Martin Nugent
01254 828060
D3/12/0241

Drafted 10 April 2012

**Planning Application, Ribble Valley District
D3-12-0241 Chatburn Village Motor Co., Sawley Road, Chatburn**

3

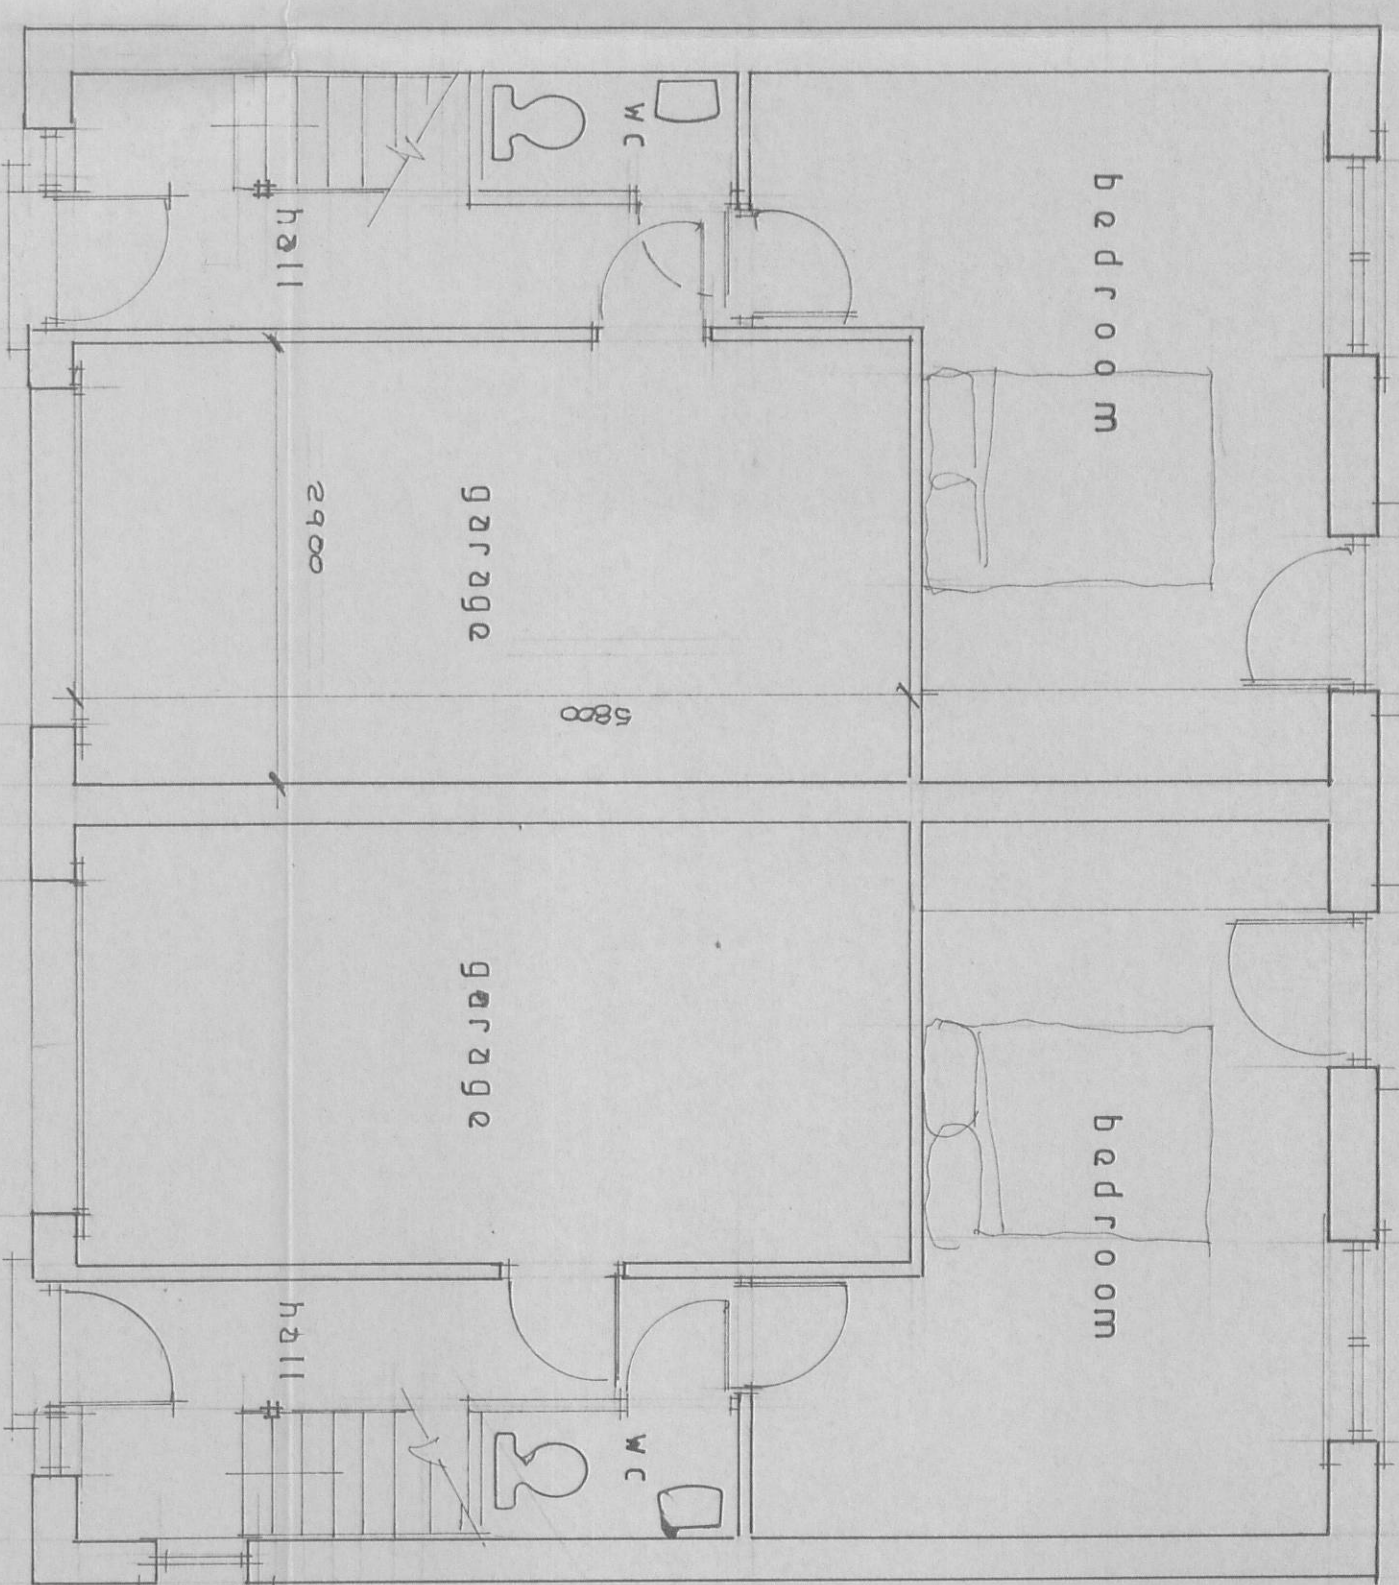
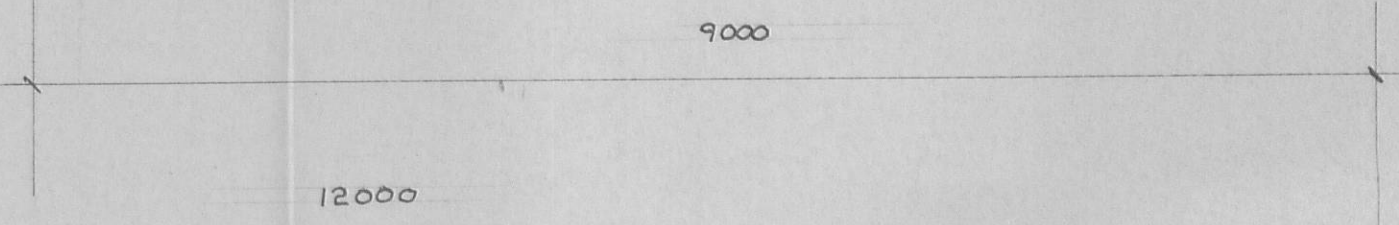
The revised plans identify an access from Sawley Road of 4.5m and off street parking for two vehicles at each unit. For three of the units, 2, 3 and 4, this includes one within an integrated garage and the other from the driveway. The garage dimensions are shown as 5.8m by 2.9m and the driveway provides a space of 5.0m by 2.5m. Both of these dimensions are satisfactory for the safe movement of vehicles.

In addition, as Unit 1 does not have an integral garage, there is a driveway and access to additional parking within the site.

I would recommend that a Condition be attached to any successful application that seeks to retain the use of the garages for their intended purpose and to prohibit their future conversion to residential living space.
